**Consultation Response from KC,  
Highways Development Management**

**2025/91579 The Homestead, Hurst Knowle, Almondbury, Huddersfield, HD5 8SG**

**Demolition of the former Homestead care home and erection of 28 dwellings, comprising 20 apartments and 8 bungalows, with access from Hurt Knowle and associated external works including landscaping**

**Date Responded: 27-8-2025.**

**SITE PLAN - Proposed**
1 : 500

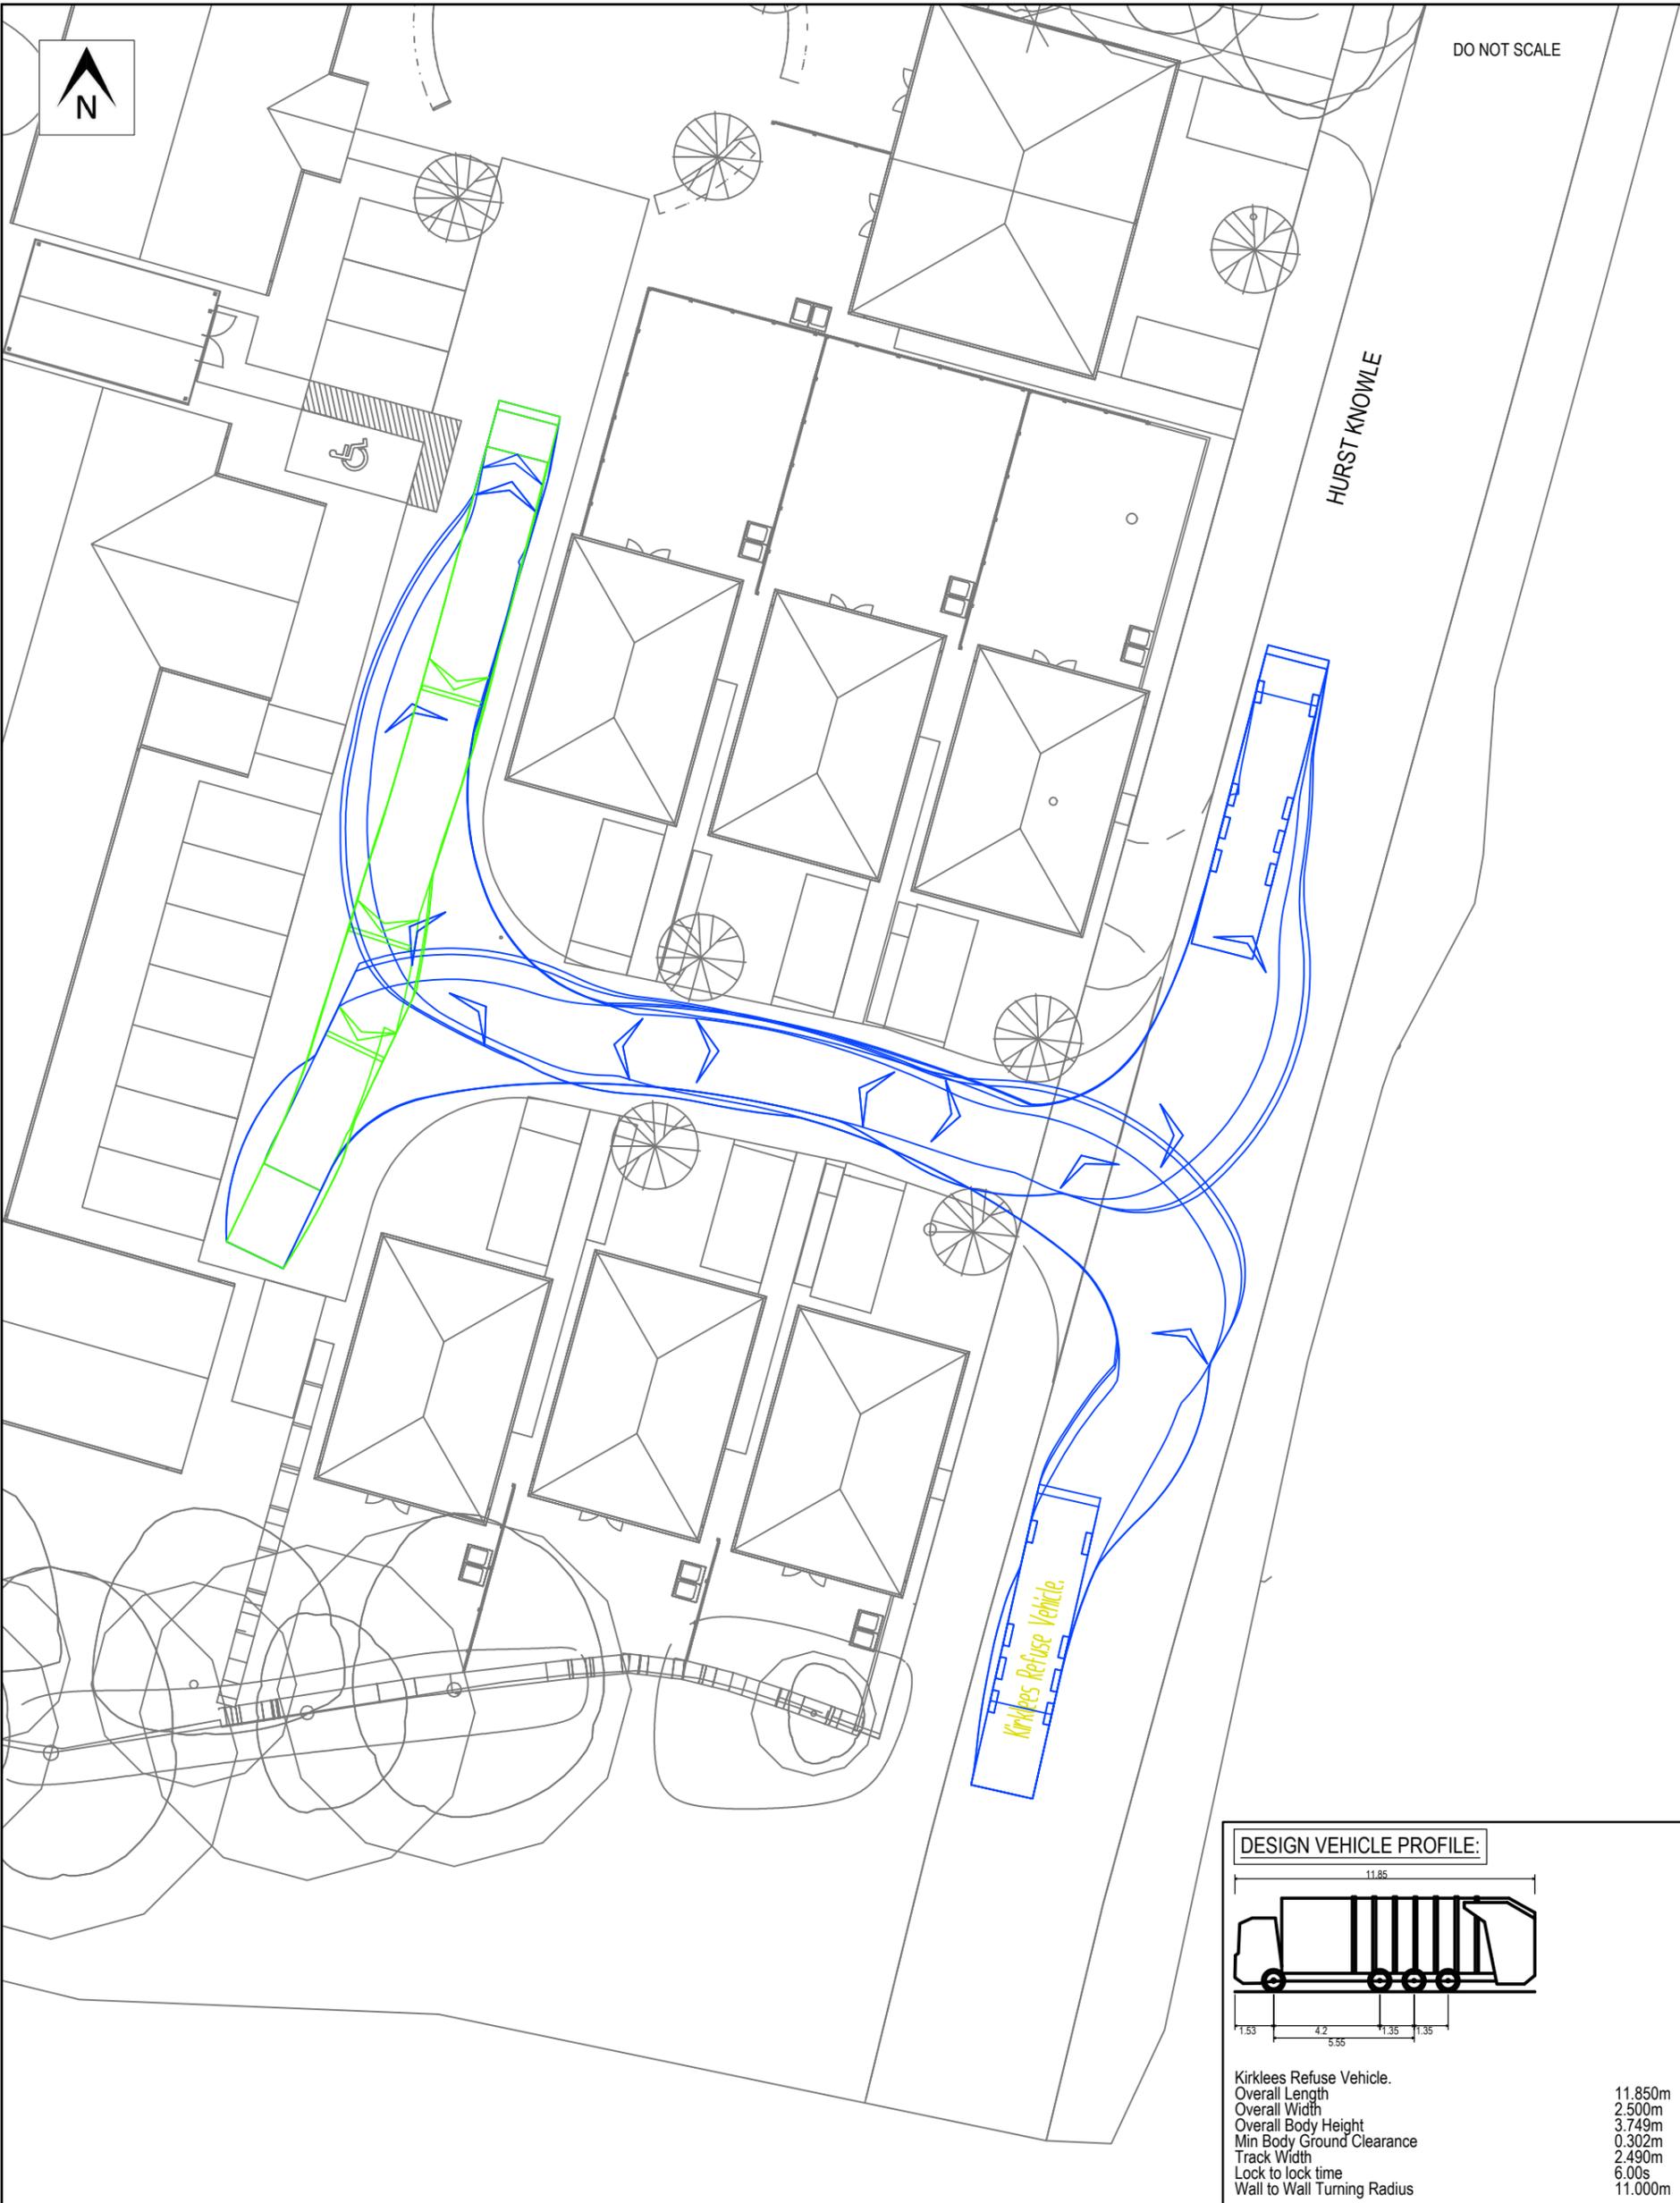
1, No pedestrian access is shown to be provided into the site. A 2.0m wide footway should be provided.

No information is provided to justify the number of parking spaces proposed based on the applicants experience at these sites.
